### **EPA Additional Advice on Environmental Impact Statement – SSD-10450**

I refer to your request for advice requesting a review by the NSW Environment Protection Authority (EPA) of the Environmental Impact Statement (EIS) for the proposed Padstow Resource Recovery Facility (Application SSD-10450) (Proposal) at Lot A DP103140 also known as 81 Gow Street, Padstow NSW 2211 (Premises). I also refer to EPA correspondence (referenced DOC21/825860-10) dated 21 October 2021 related to EPA's partial response to your request for advice on this planning proposal (First Response).

### NSW Environment Protection Authority (EPA) Submission on Environmental Impact Statement (EIS) for proposed Padstow Resource Recovery Facility (Application SSD-10450) at 81 Gow Street, Padstow NSW 2211

Figure 7-5: PM₁₀ 24 Hour Averaging Period Modelling Results – Scenario 1

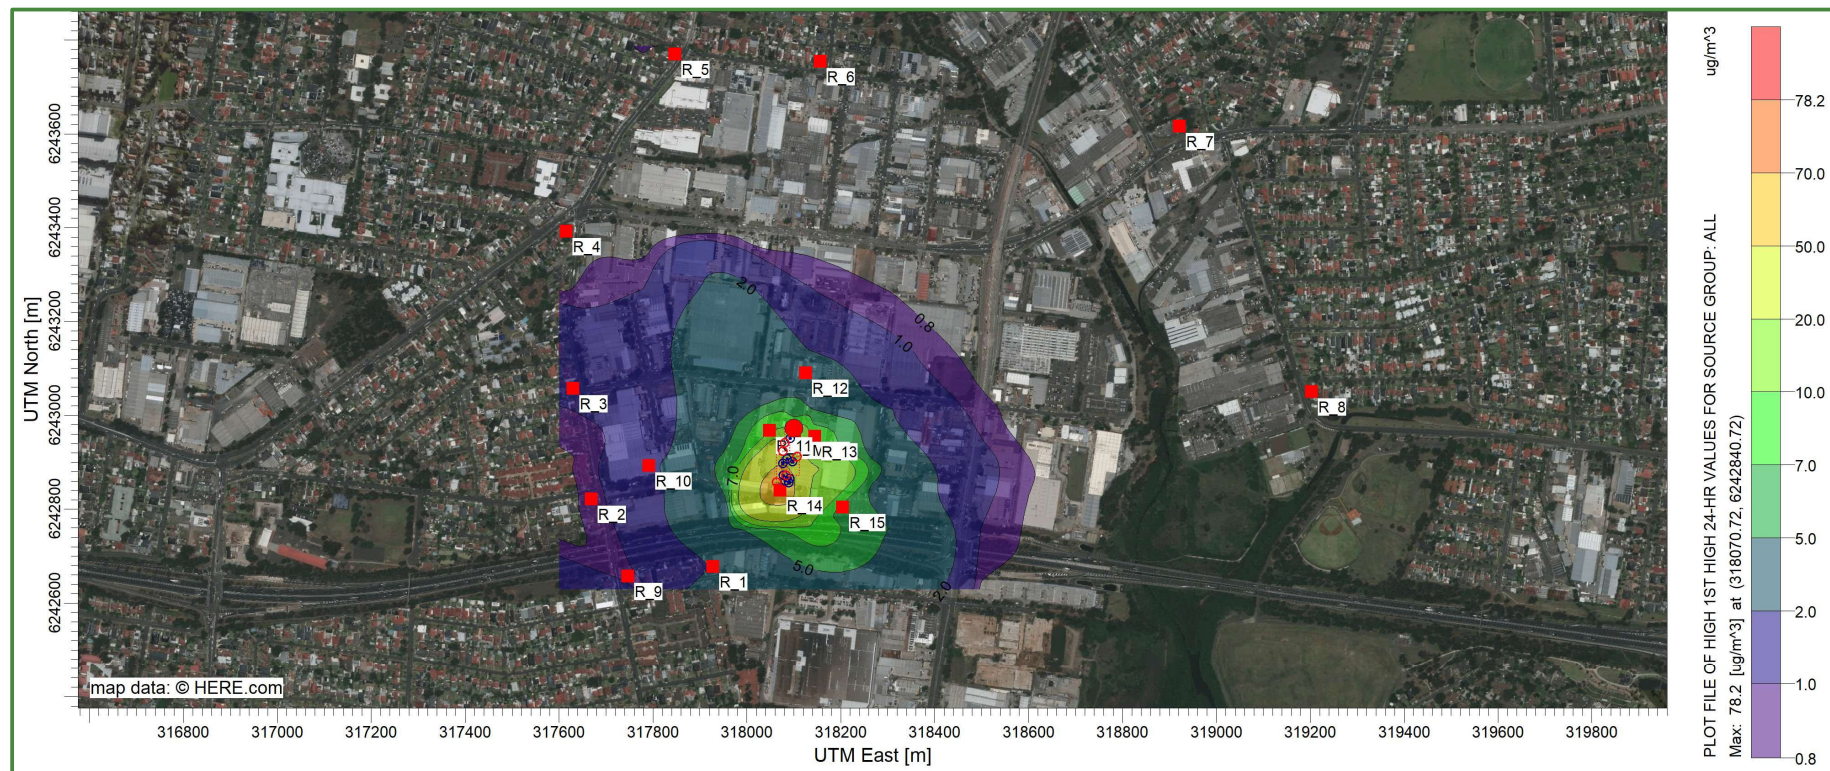
Incremental dust impacts from the development are predicted to be significant at a number of industrial receptors for modelled scenario 1. Lower ground level concentration, but still appreciable, impacts are predicted under scenario 2, with the incorporation of mitigation measures. Examples include;

- Incremental PM10 (24-hour) impacts at the industrial receptor (R14) are predicted to be 43.0 ug/m<sup>3</sup> (scenario 1) and 12.1 ug/m<sup>3</sup> (scenario 2).
- Incremental PM10 (24-hour) impacts at the industrial receptor (R11) are predicted to be 19.8 ug/m<sup>3</sup> (scenario 1) and 16.2 ug/m<sup>3</sup> (scenario 2).

PROPOSED SITE PLAN

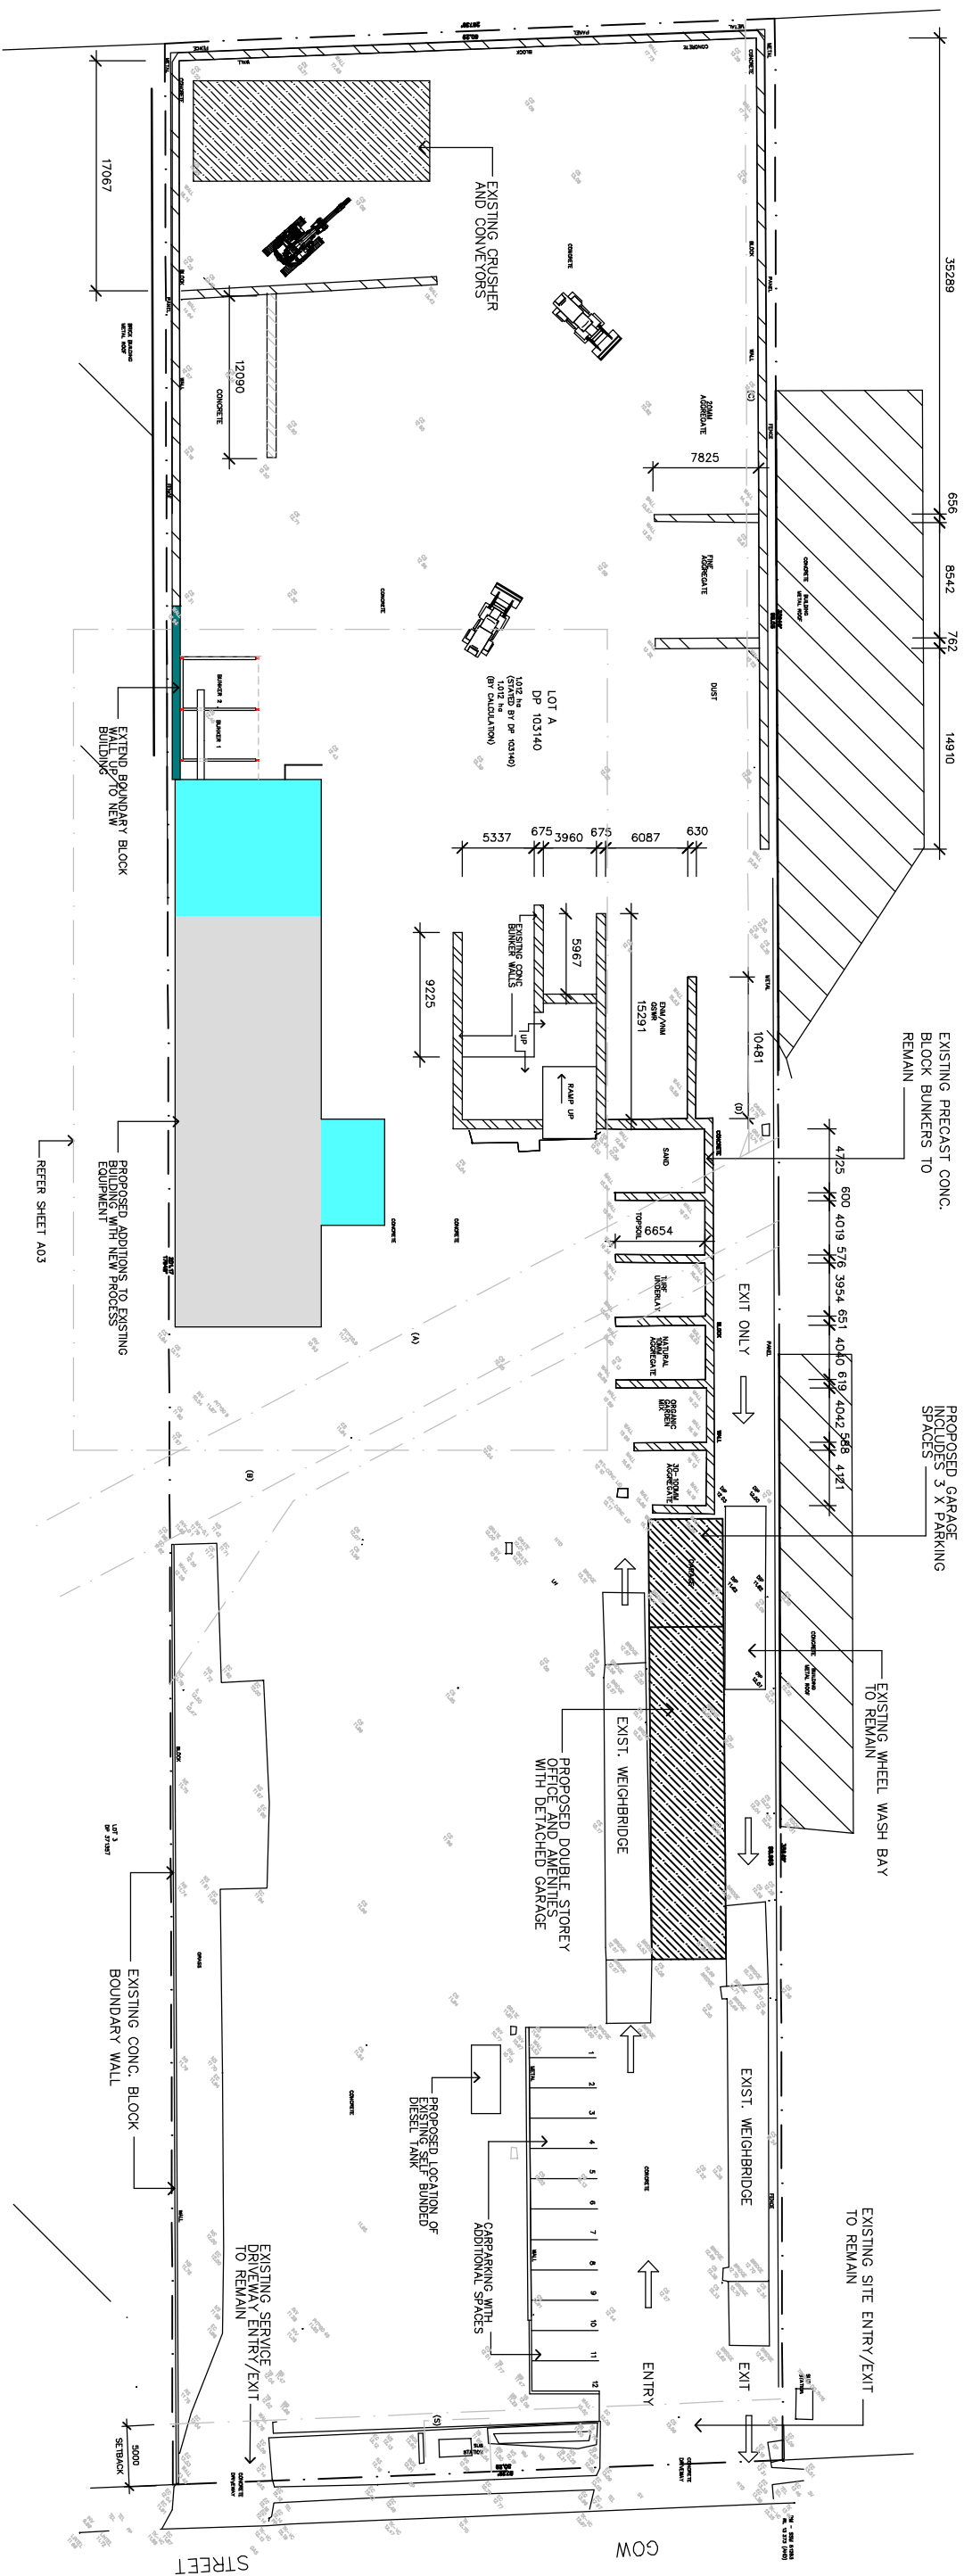
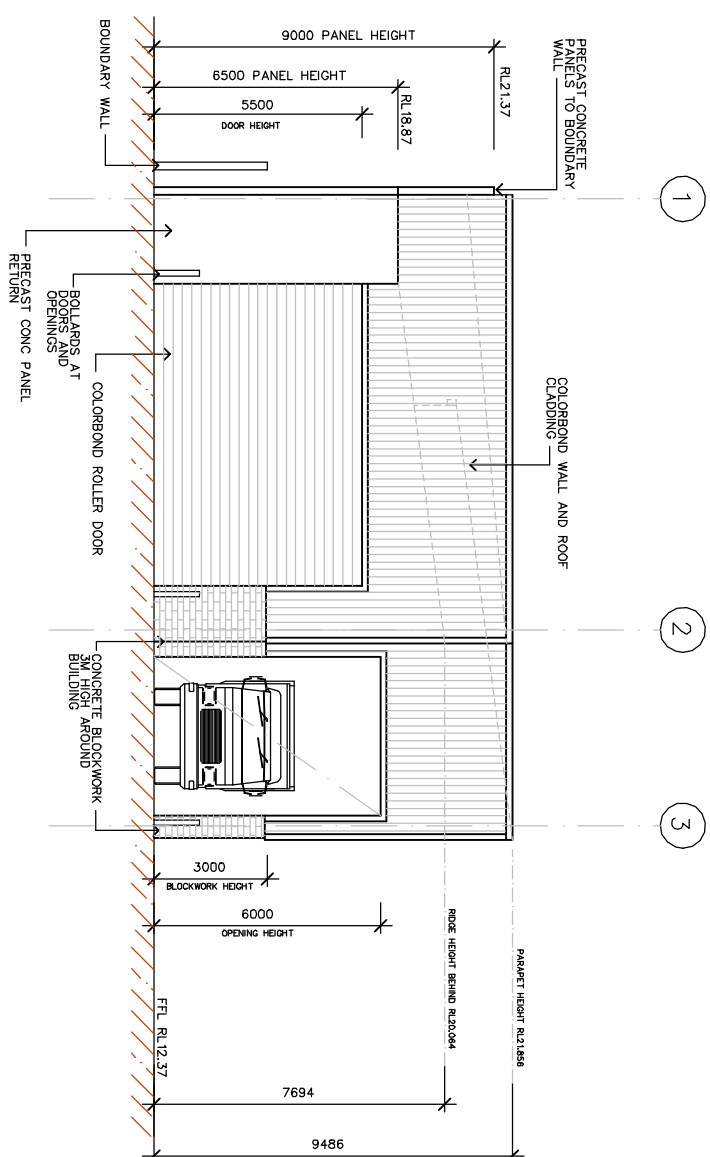
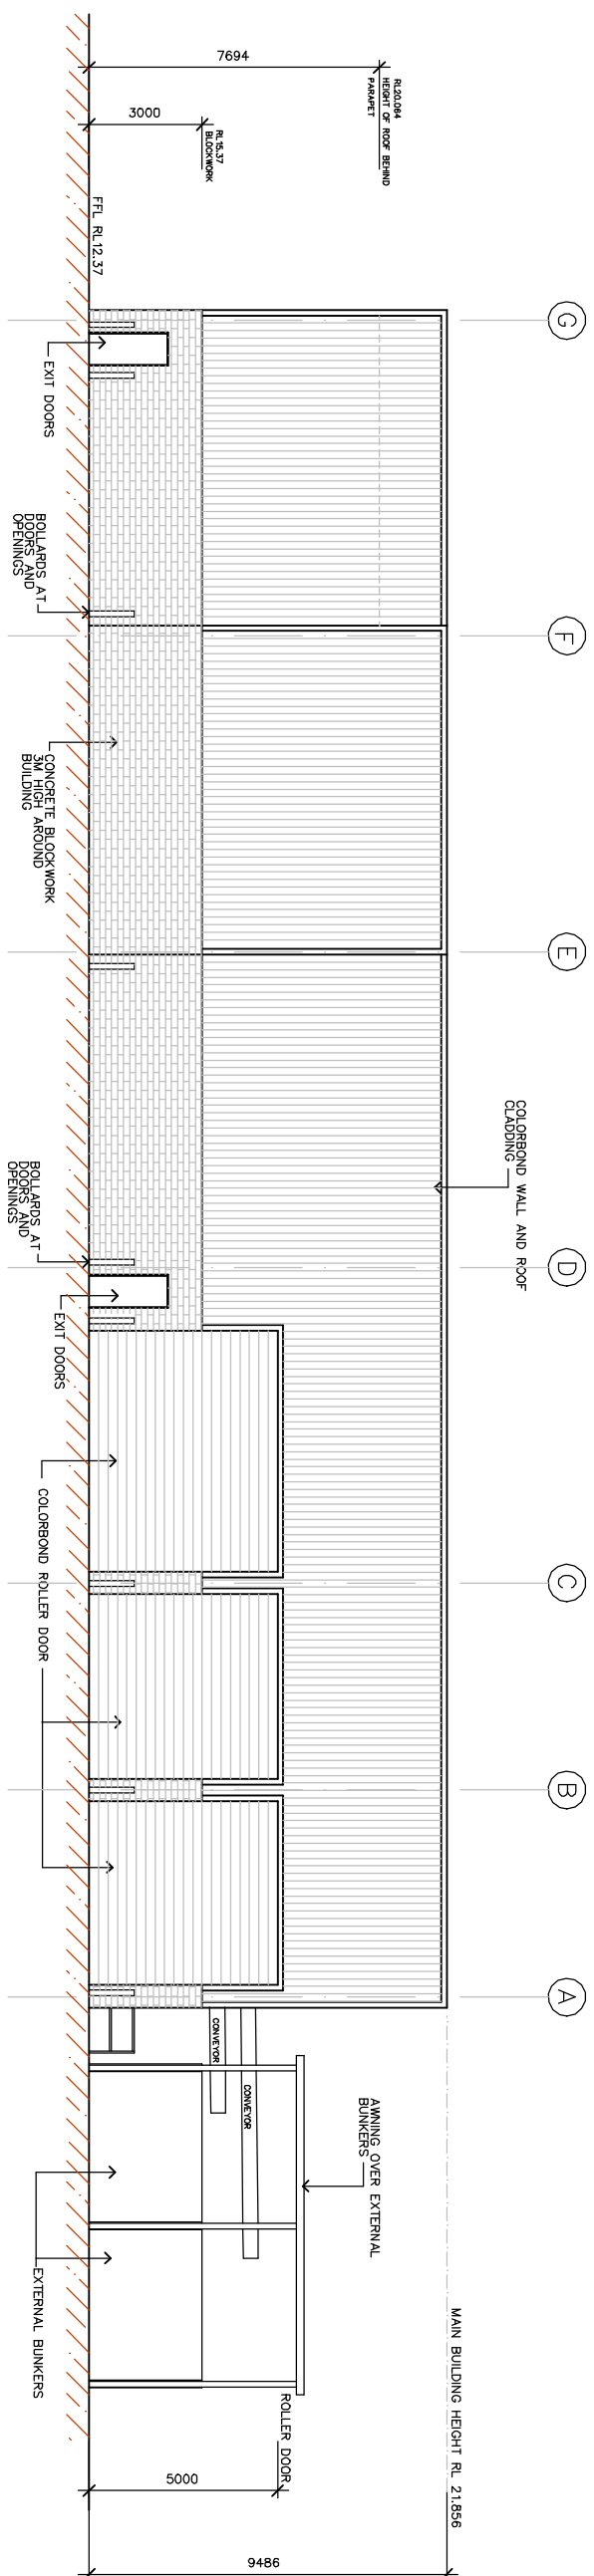
The EPA has significant concerns around the safety of the 65,000L bunded diesel fuel tank as outlined in Sections 5.6 & 5.7.2 of the EIS. Given the petroleum product is classified as a dangerous goods, the EPA requests justification for the size and position of the tank as shown on the site plan, as part of the proponent's documentation, including:

- Detail about the reason that the Applicant is proposing to store 65,000 litres of diesel at the premises.
- Detail around mitigation procedures must be included as part of the justification for the design and volume of the bunded fuel tank as outlined in the proposal.
